OXFORDSHIRE COUNTY COUNCIL'S RESPONSE TO CONSULTATION ON THE FOLLOWING DEVELOPMENT PROPOSAL

Application no: 23/03428/OUT

Proposal: Outline planning application for the construction of up to 140,000 sqm of employment floorspace (use class B8) with ancillary offices and facilities and servicing and infrastructure including new site accesses. Internal roads and footpaths, landscaping including earthworks to create development platforms and bunds, drainage features and other associated works including demolition of the existing farmhouse.

Location: OS Parcel 7921 South Of Huscote Farm And North West Of County Boundary, Daventry Road, Banbury

JOB TITLE		LAND AT M40 J11		CLIENT		GREYSTOKE	
DRAWING TITLE							
A361 ROUNDABOUT WITH SECONDARY ACCESS							
SCALE	DRAWN BY	DATE	DRAWING No	REVISION			
1:1000@A1	RM	04/12/23	23457-07-01GA	C

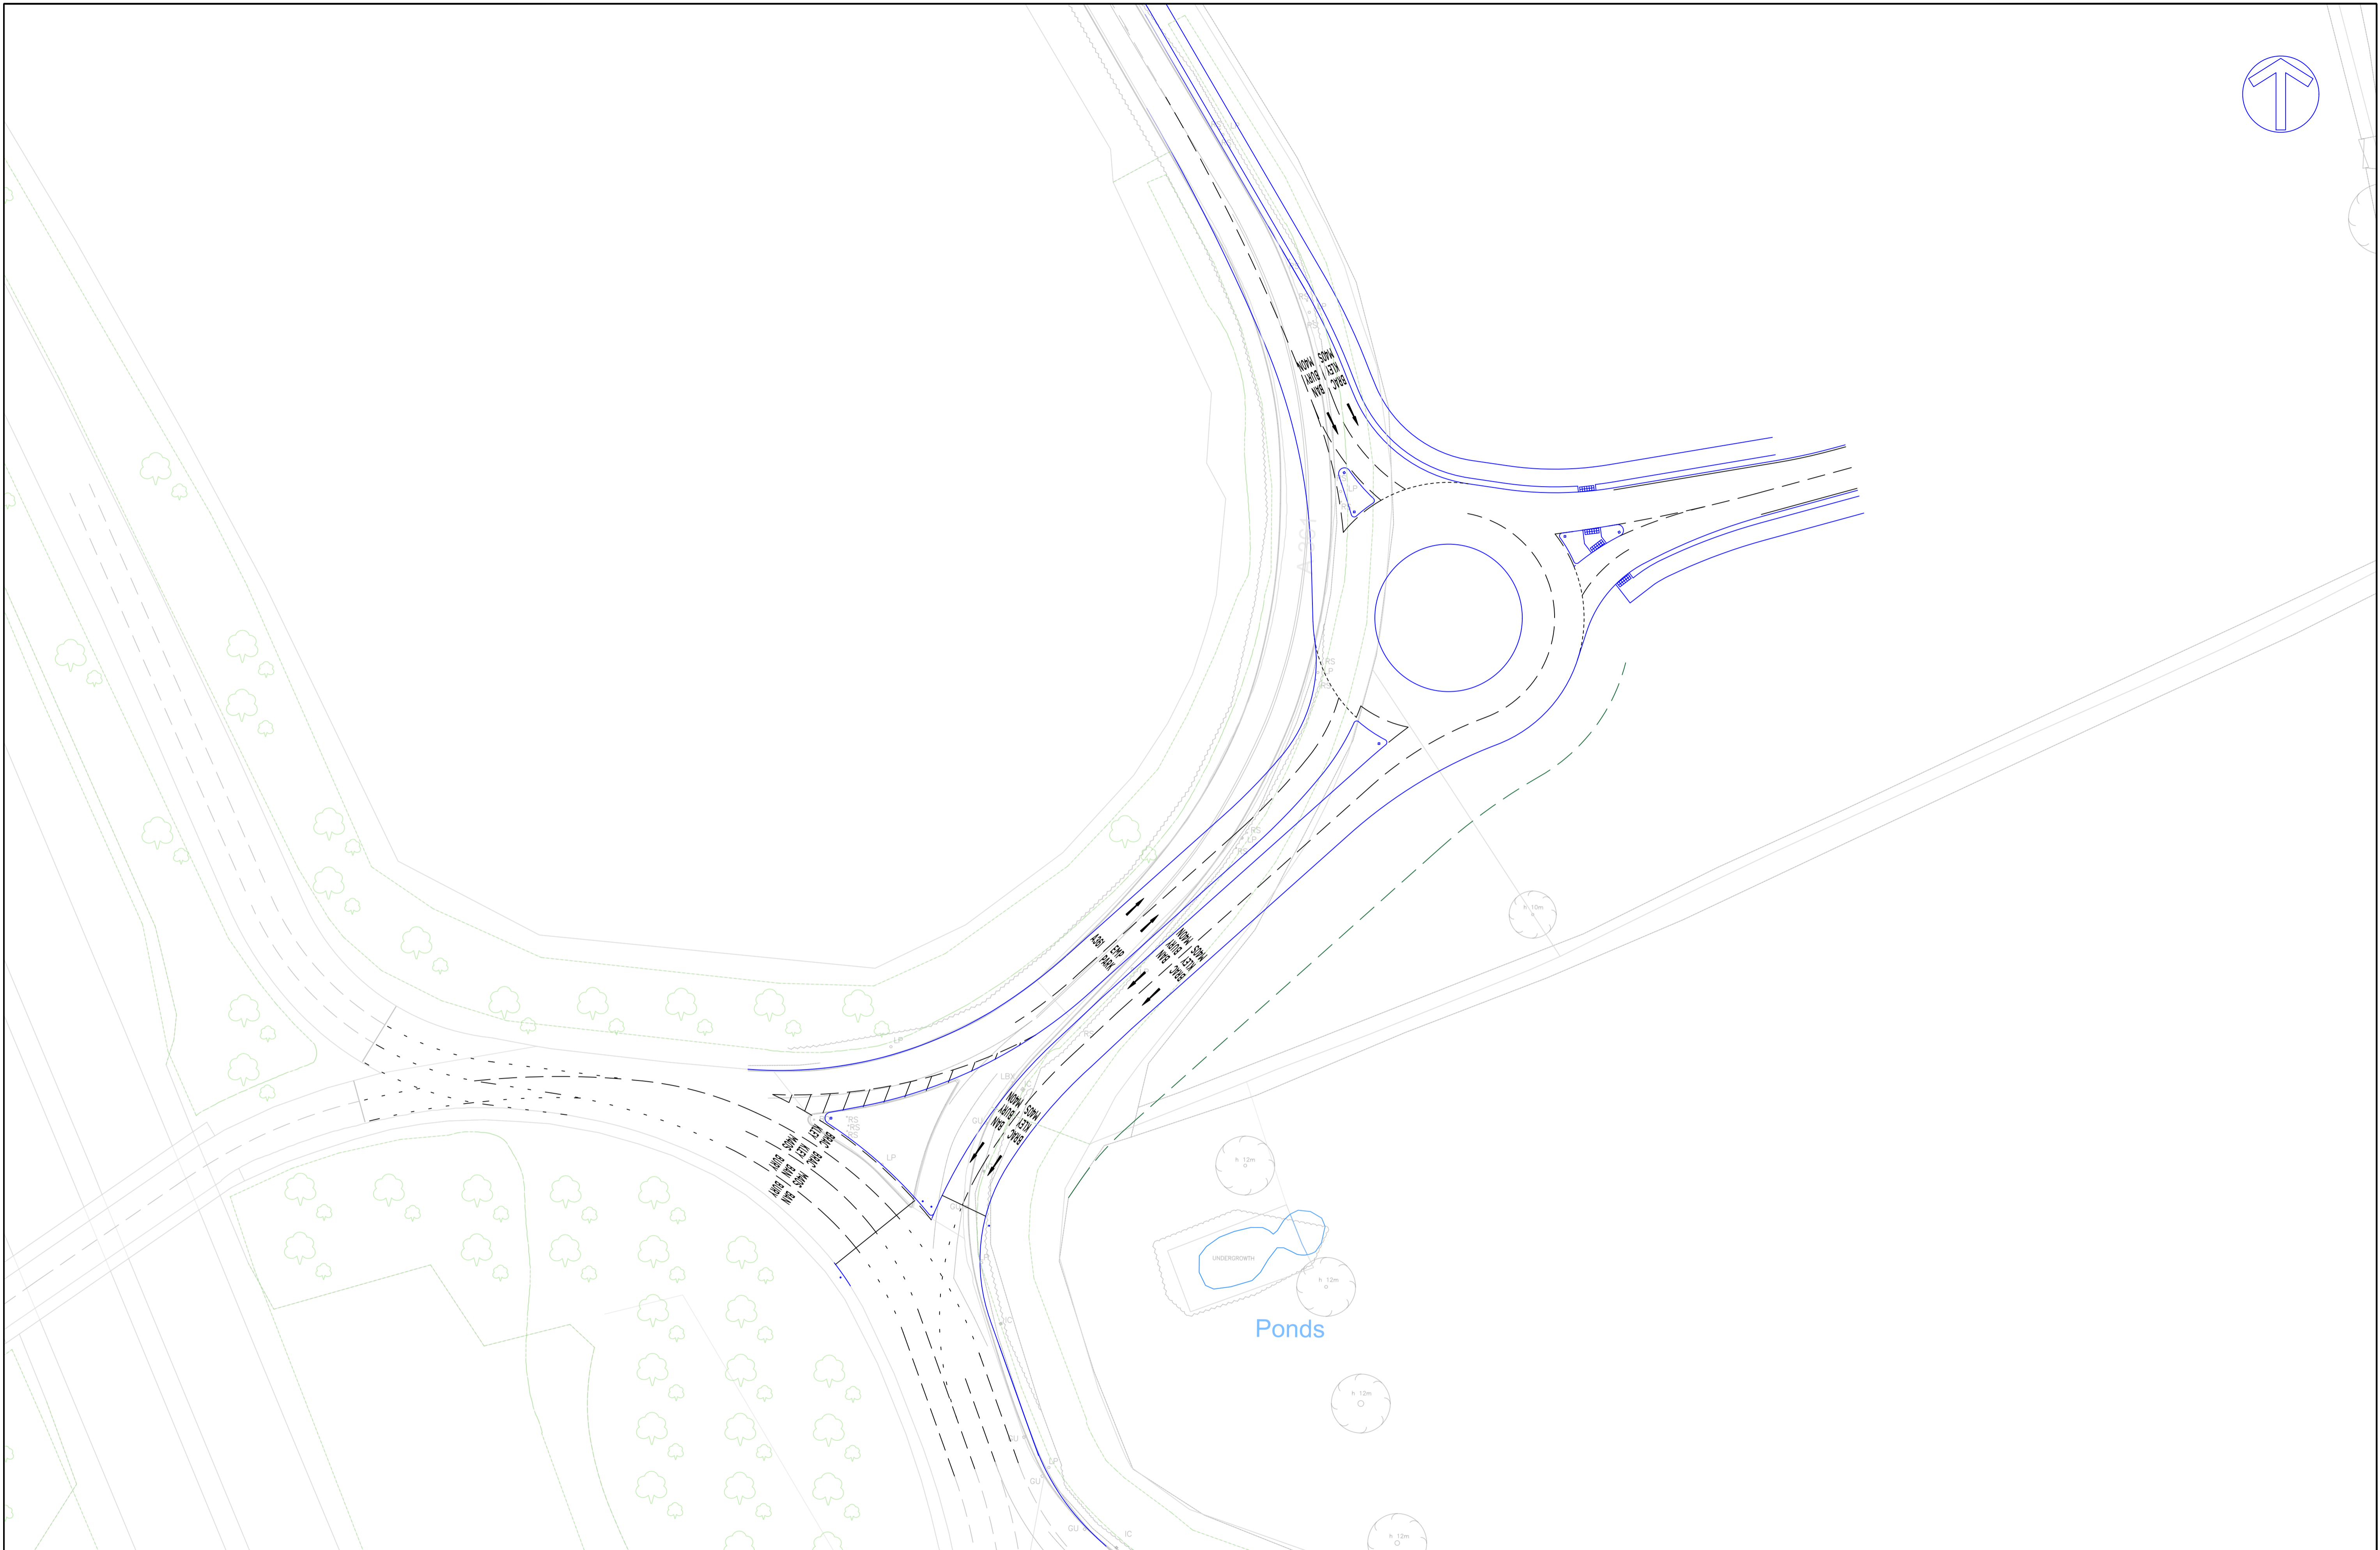
The primary access would be a three-arm roundabout located just a little over 100m from the A361 exit on to the Junction 11 roundabout. This proximity is likely to cause occasional severe congestion issues and is a reason for objection. See further discussion below under Traffic Impact. The Road Safety Audit raised no concerns in respect of road signs, carriageway markings and lighting.

The secondary access would be a priority junction, approximately 450m north of the primary access and approximately 200m north of the Frontier Park junction. A filter lane would be added to the A361 for right-turning inbound vehicles.

A Road Safety Audit has been included in the Transport Assessment. It is noted that the audit considered Rev. B of Document ref. 23457-07-01GA, A361 Roundabout with Secondary Access. This revision does not include the proposed upgrade of the existing pedestrian crossing to a Toucan crossing, which appears on Rev. C, so the auditors would have been unaware of this intended modification. Therefore, an objection is maintained as it has not been demonstrated that the crossing is in a safe and suitable location. Furthermore, there is no apparent direct access for pedestrians or cyclists into the site close to the crossing, with the shared use footway/cycleway shown to be continuous between the two vehicular access points that provide the only ways in. This lack of permeability does not constitute suitable access.

Figure 2: Signal Mitigation on A361 at Junction 11

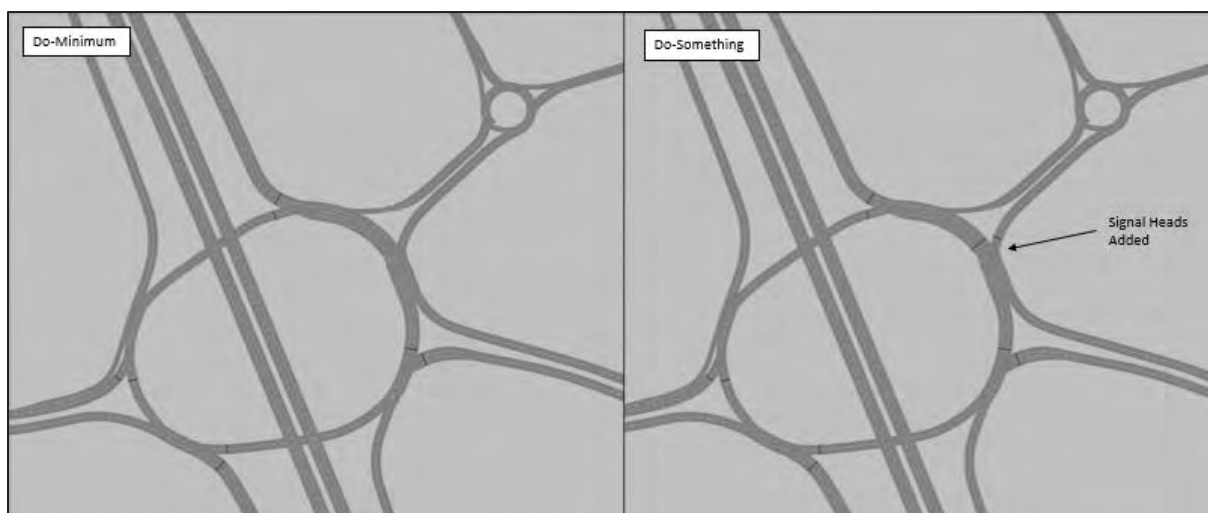
- Based on the current modelling results, the proposed signalisation of the A361 does not mitigate the impacts of development.
- It has not been demonstrated that a signalised crossing of the A361 for pedestrians and cyclists may be incorporated at a safe and suitable location, and an appropriate access into the site is not proposed.
